Date :- 18/10/2023

Observations on the following Planning Applications

23/02399/REM

Proposal : Ward: South
Proposal: Reserved Matters approval for 23/01080/OUT - Details of access, appearance, landscaping, layout and scale relating to the proposed development of Class E(g)(i) (formerly B1(a)) office/commercial building and Class E(g)(ii) (formerly B1(b)) Research and Development Units, plus associated car parking.

PROJECT Bicester Arc - YASA - R&D
TITLE ROOF PLAN

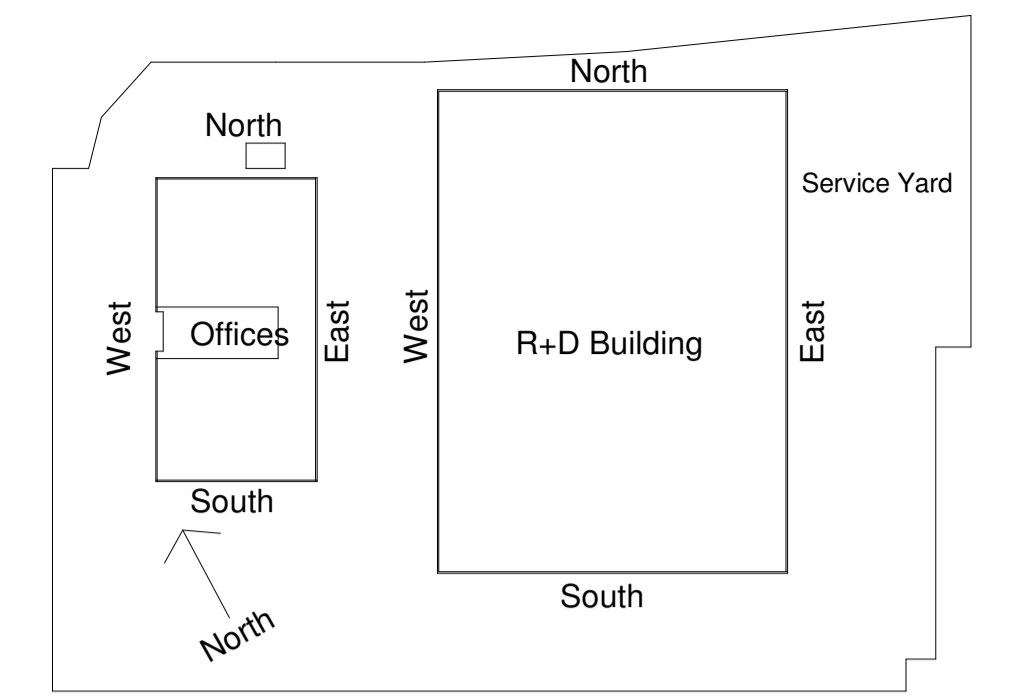
Observations : RESOLVED that Bicester Town Council has no objections to this planning application and request that the roof will support solar panels.
